Re: Application #: MP09_0016

I am writing in regards to the abovementioned application for the Scottish Hospital Redevelopment. I am owner in the apartment block of 40 Stephen St, and I am quite horrified at the changes being proposed, and the impact they will have to the street.

STEPHEN STREET ELEVATION

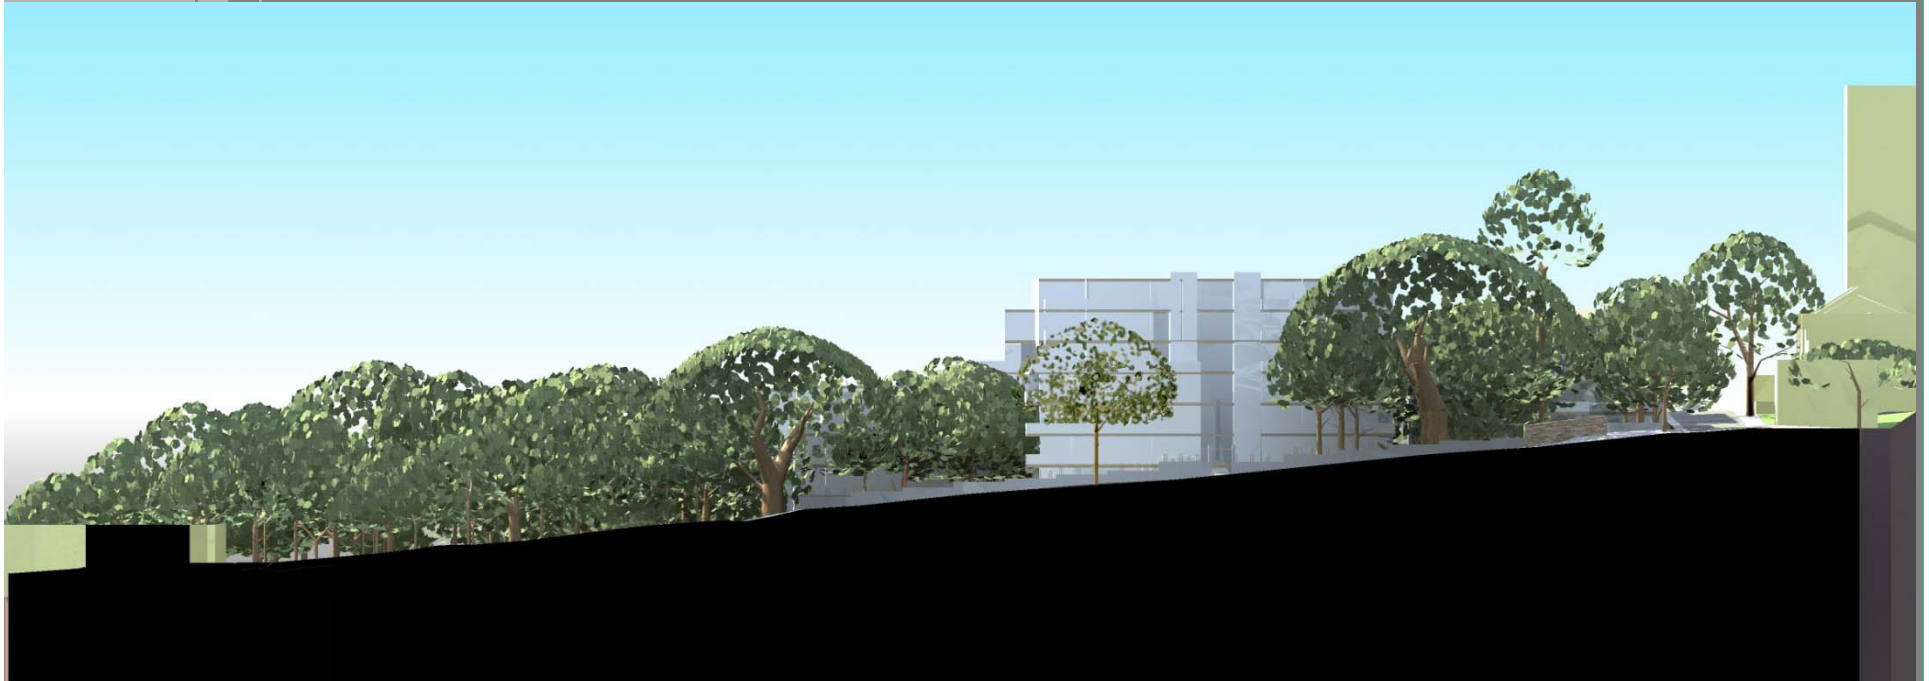
2 – The aged care facility is to be built right on the edge of Stephen St – The SEPP 65 Recommendation is for 18 meters, but this development is proposing 16 meters.

4 – Air conditioning units located opposite 40 Stephen St - These will once again have a massive impact on the residents of 40 Stephen St with the noise that will be produced.

Whilst consideration has been given to the residence of Brown St, with the appearance remaining mostly untouched, it appears that the same has not been afforded to the residence of Stephen St, and the massive impact this development will have on their standard of living.

Scottish Hospital | Stephen Street

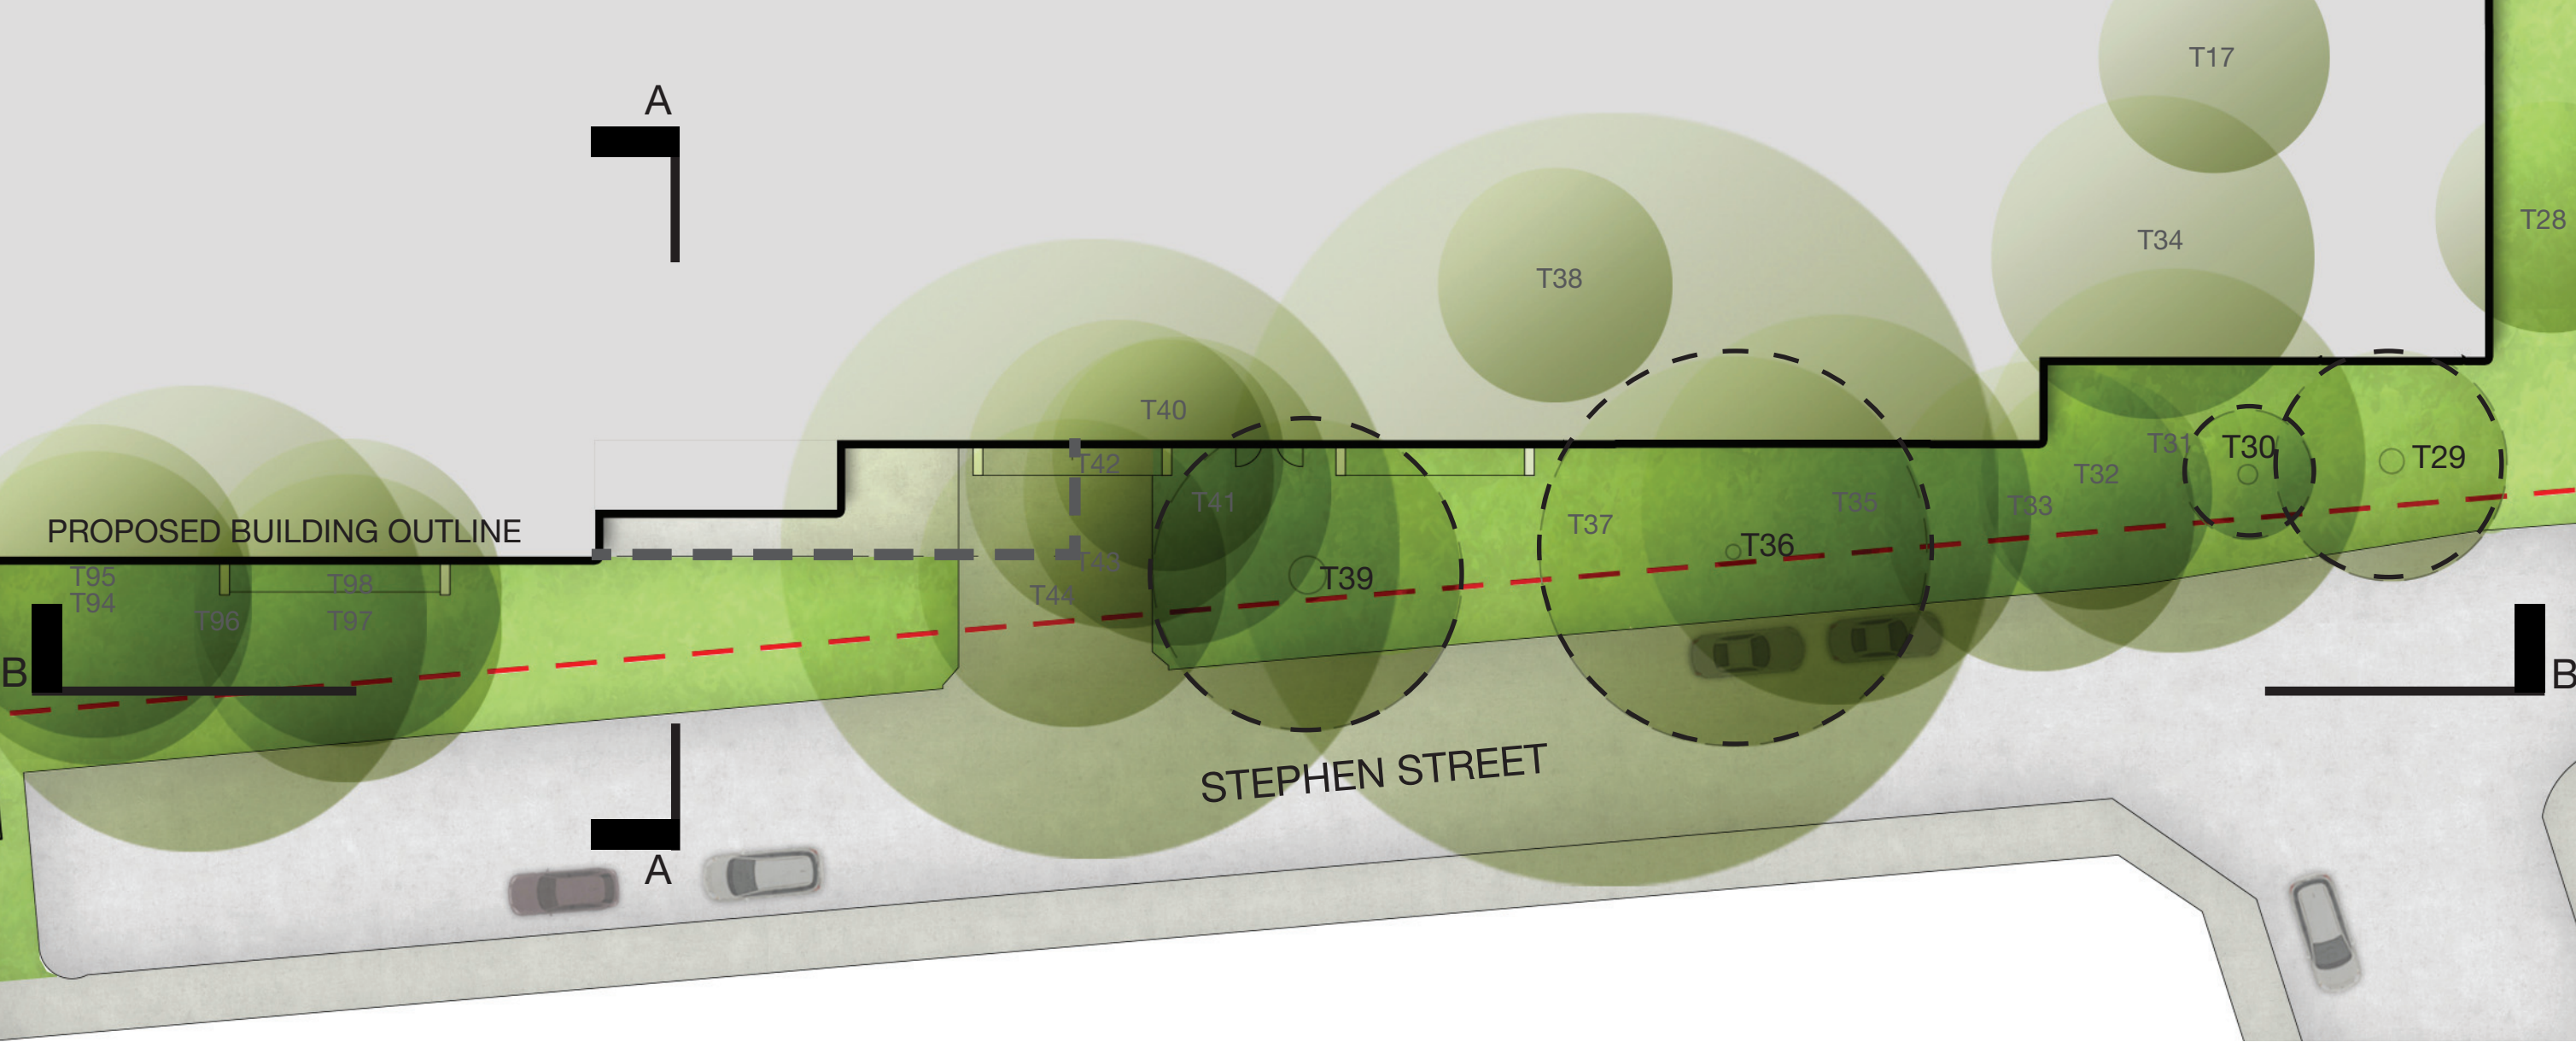
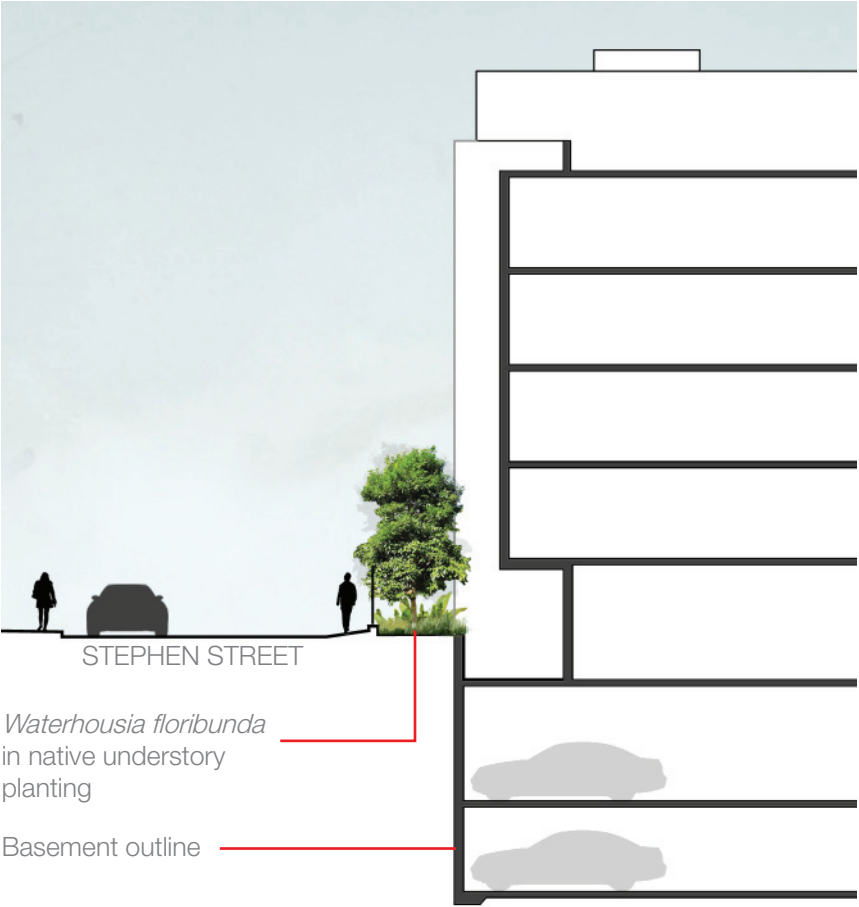
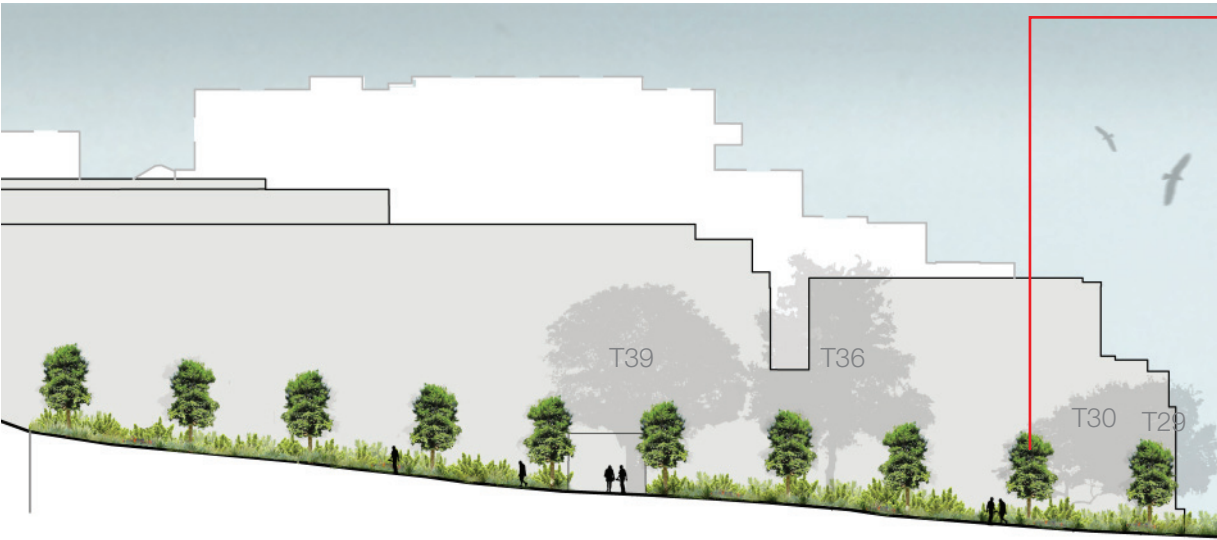
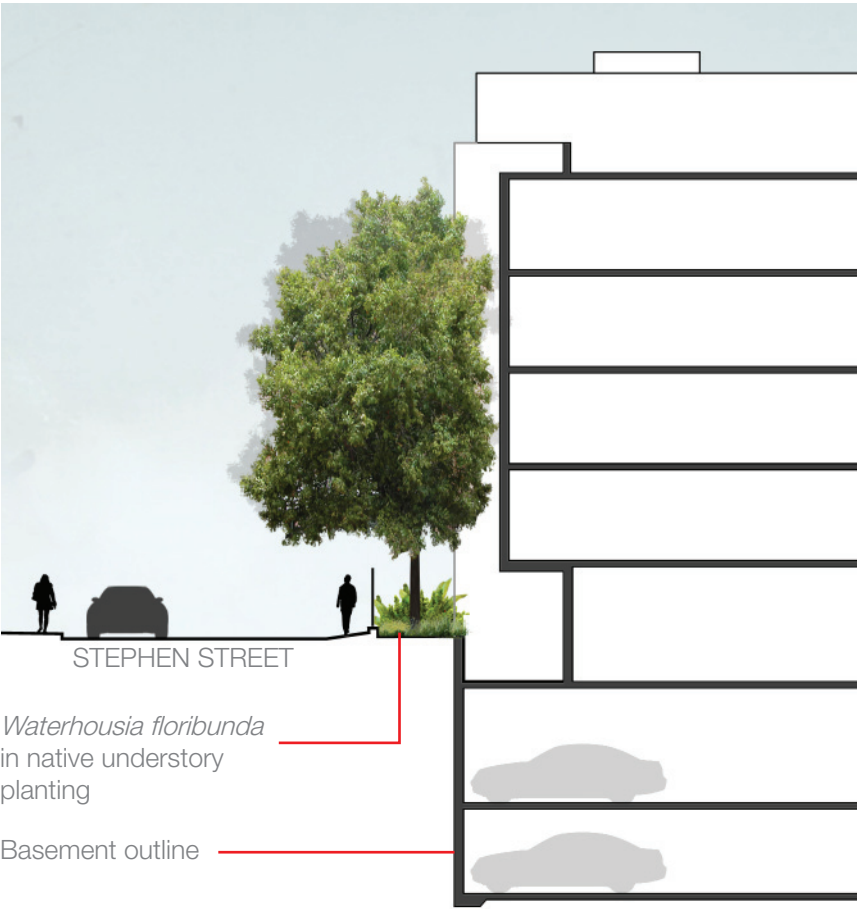
1 – Removal of trees - There are notes to remove all 'retention value B' trees from Stephen St. These trees are a major asset to the street, and their removal will impact the feel and look of the street substantially.

The Woollahra council tree preservation order says that nine of the trees must be preserved, but the application has ignored these, even calling some of them weeds when other trees of the same species are to be retained in the same proposal.
